Ribble Valley Borough Council
Council Offices
Church Walk,
Clitheroe
Lancashire
BB7 2RA

Phone: 0300 123 6780
Email: developeras@lancashire.gov.uk
Your ref: 3/2025/0564
3/2025/0565
Our ref: 3/2025/0564/HDC/KW
3/2025/0565/HDC/KW
Date: 29 January 2026

Location: 45 - 47 Whalley Road, Clitheroe, BB7 1EE
Proposal: Planning permission for proposed change of use from light industrial to residential (use class C3) and commercial (use class E(c)(iii)) involving internal and external alterations.
Grid Ref: 374236 441280

C Mezzanine Plan
Scale: 1:100

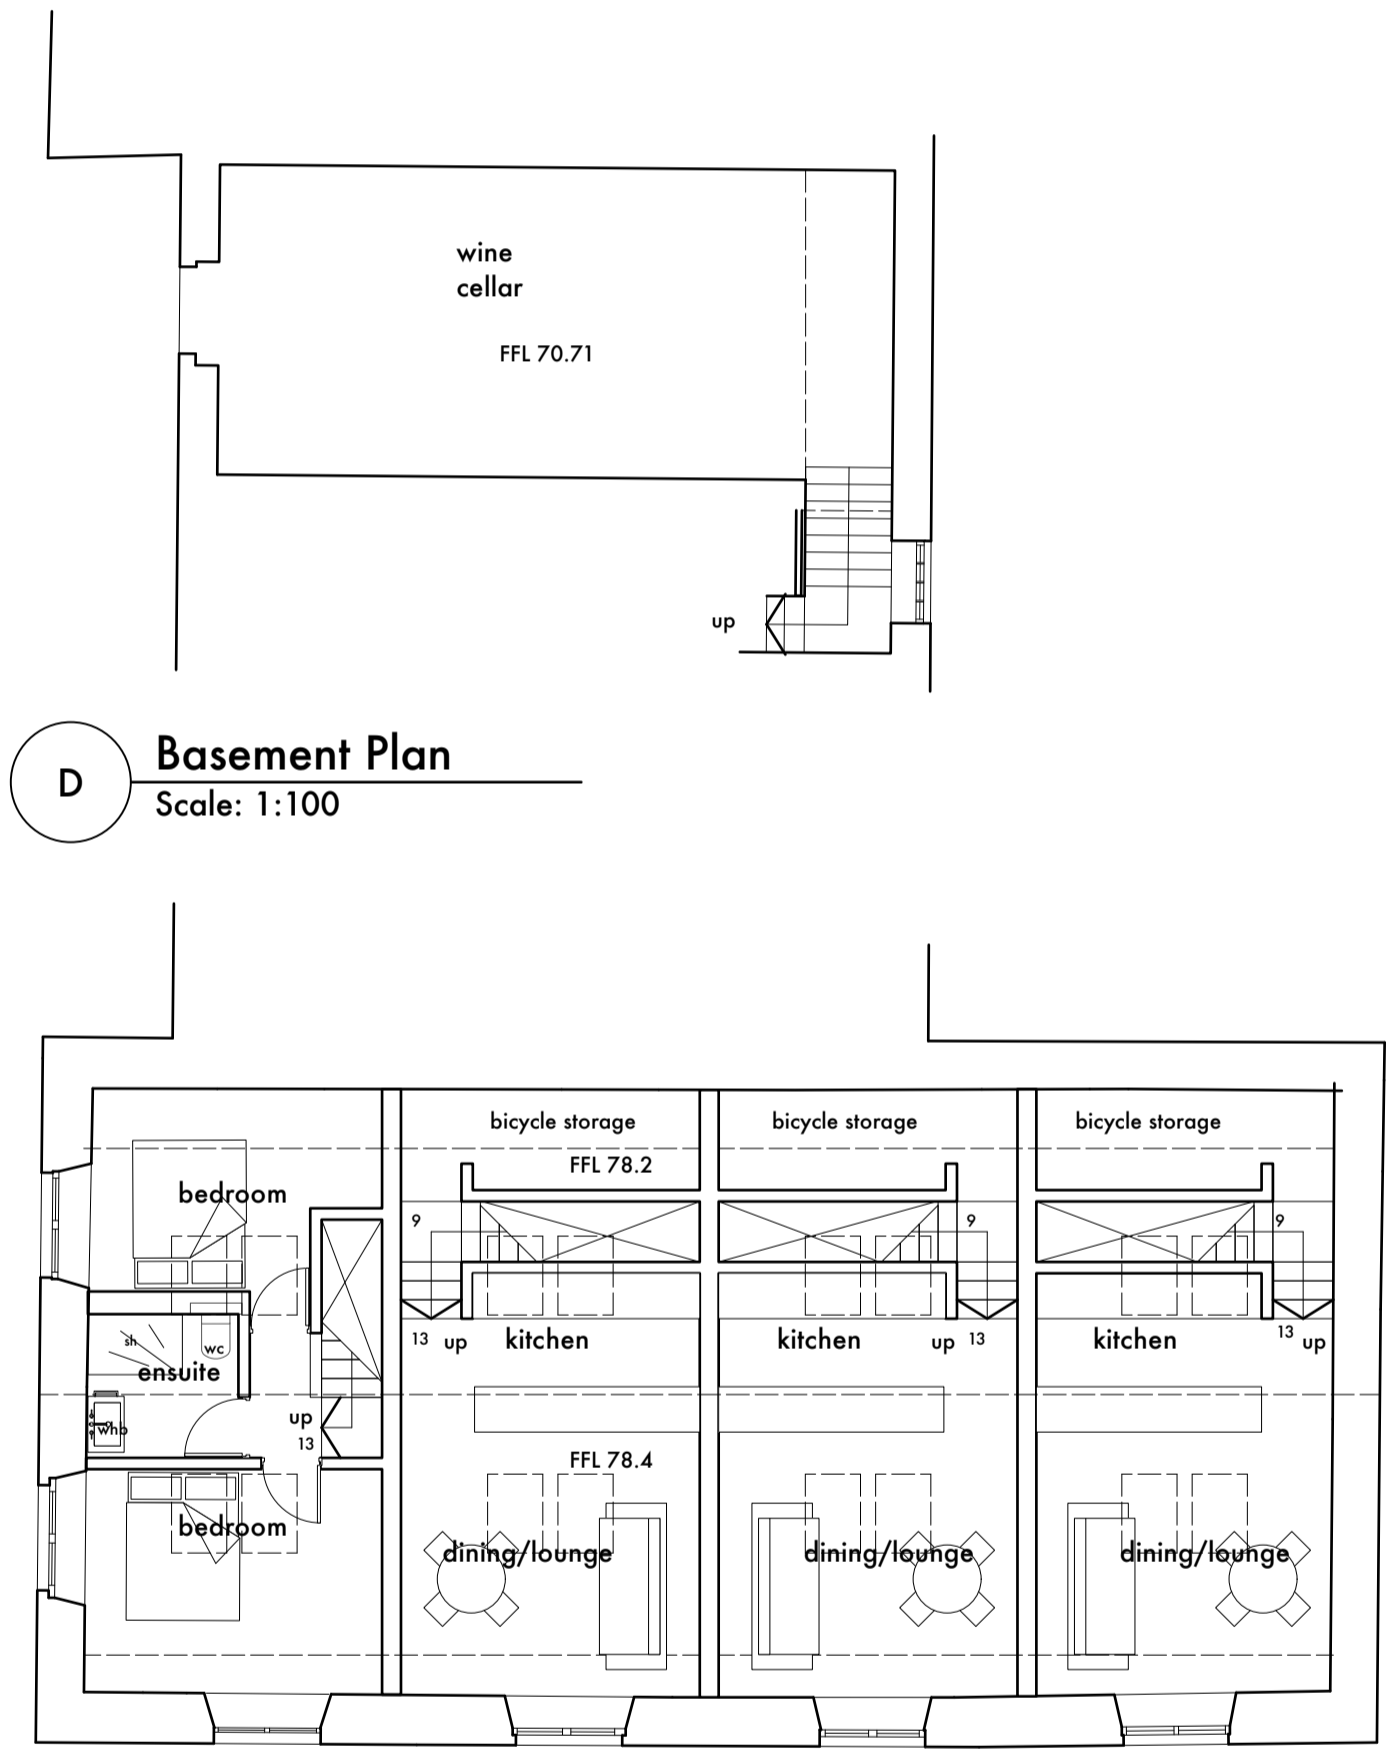
The LHA has reviewed drawing number PL01 Rev D. Currently, six parking spaces are proposed within the parking area, allocated to the residential element of the development.

Two spaces are designated for the four-bedroom dwelling. The LHA would expect three off-street parking spaces for dwellings with four bedrooms or more. Given the sustainability of the area, situated close to amenities and public transport options, the LHA would accept a shortfall of 1 parking space for the 4 bedroom dwelling and will condition that cycle storage is provided within the site to further encourage and promote sustainable transport.

Four parking spaces are allocated for the flats. Drawing number PL02 Rev A indicates that three one-bedroom flats and one two-bedroom flat are proposed. In accordance with the LHA's parking standards (as set out in the Joint Lancashire Structure Plan), one-bedroom flats should be provided with one off-street parking space each, and two-bedroom flats should be provided with two.

Although the LHA have not yet updated their parking standards following the introduction of Class E use, the LHA applies an average of one car parking space per 35 square metres for Class E uses. Based on the internal floor layout, Unit 1 would require two parking spaces, and Unit 2 would require one.
